**From:** Claire Hall [mailto:  
**Sent:** 08 August 2019 20:12  
**To:** DC Support  
**Subject:** Planning objection 19/01177/F

**Comments on Planning application 19/01177/F**

Title : Proposed Pedestrian Facilities with Shared Space

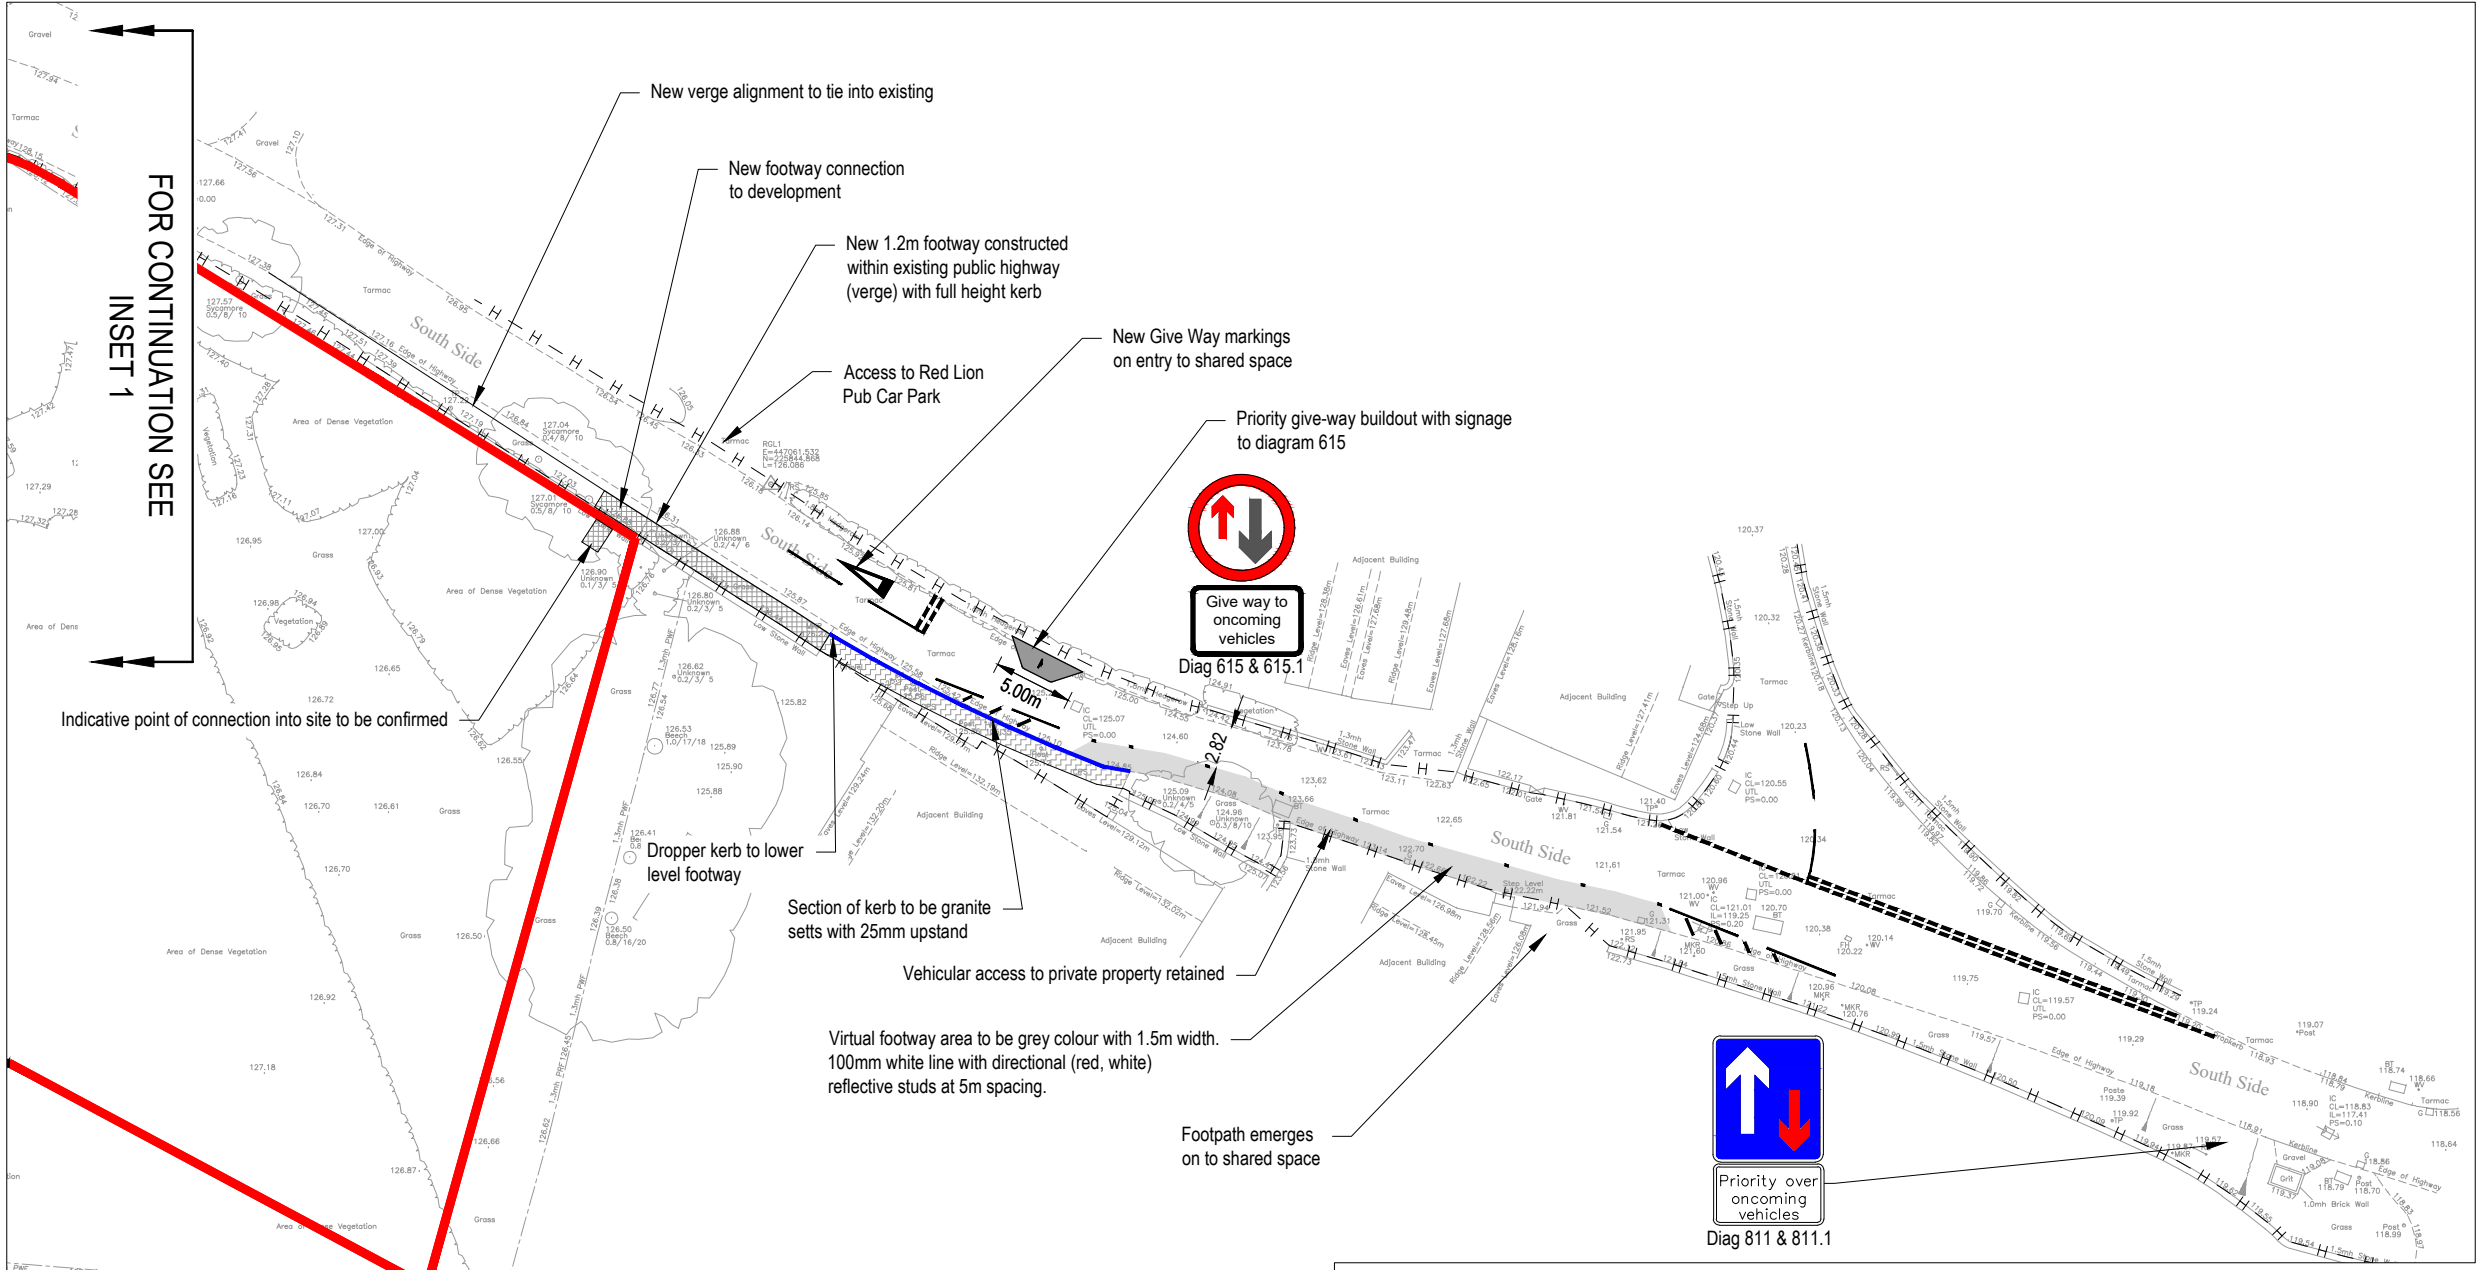
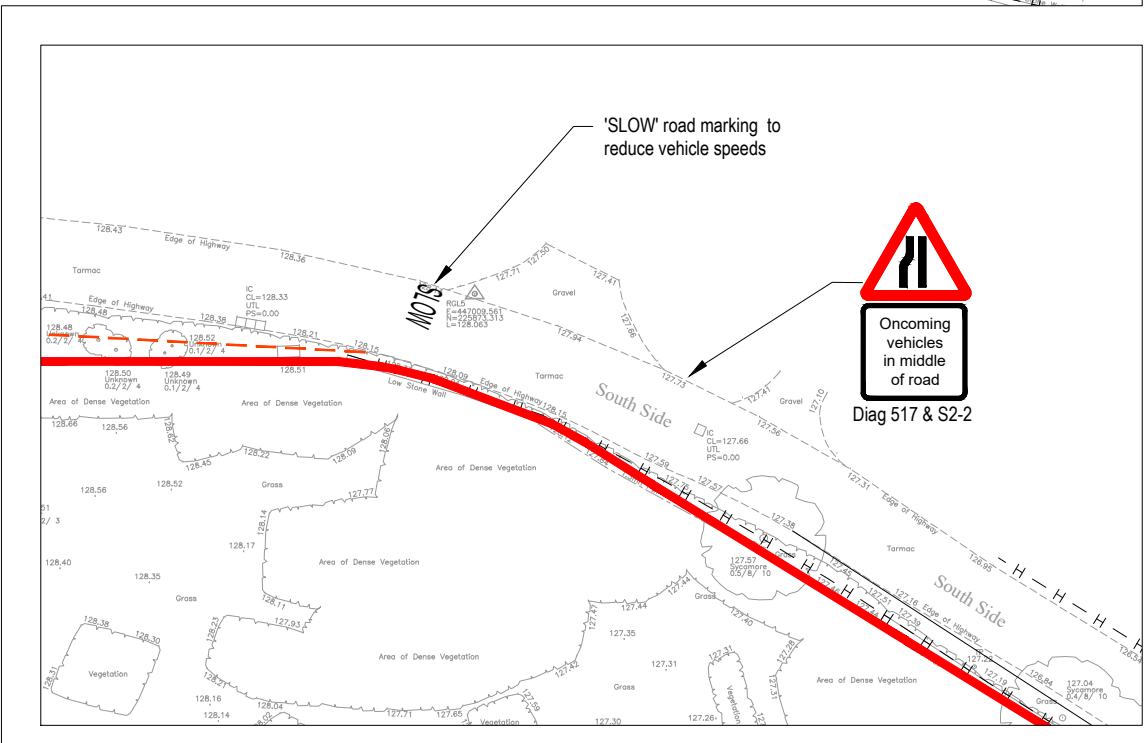
The conservation area in Steeple Aston extends westwards along South Side as far as the Telephone Exchange, to the west of the development site. The development site is therefore in a sensitive location at the entrance to the village and will affect the setting of the Conservation Area. The proposed development does not enhance the local distinctiveness of Steeple Aston. In order to provide the required visibility splays at the access point to the proposed development at least one mature existing tree needs to be removed. This will adversely affect the character of this area. The proposal of a "1.5m 'virtual footway' in buff colour with reflective studs" inset into the road is grossly out of character with the village.

The proposed new footway and virtual footway and associated priority/give-way arrangements do not provide a safe pedestrian access to the village facilities. This is unacceptable. The virtual footway means that from the give-way sign to the junction of South Side and Water Lane is effectively single carriageway. However, there is insufficient visibility to make this safe. As the attached photograph shows, a driver at the give-way point cannot see the Water Lane junction (and vice-versa) and therefore cannot see if the road is clear in order to proceed. This is because the road bends slightly, and there is a change in gradient, and the roadside hedge at the Red Lion obscures visibility. Therefore there could be two vehicles trying to pass one another at the same point as a pedestrian is walking along the virtual footway. In addition, it is proposed that there is a "priority give-way build out" on the brow of the hill, creating a single lane. This raises the potential danger further as if two vehicles did meet on this section, with a pedestrian using the footway, there would be absolutely no way they could safely get past one another. Furthermore, this road is also used regularly by wide farm vehicles and the vital village bus service, both of which currently just fit along this section of road. Any narrowing of the road would cause safety/usability issues with these road users. We would also like to note that the access to Hill House also feeds traffic into this area which will be in conflict with traffic from the development site.. T
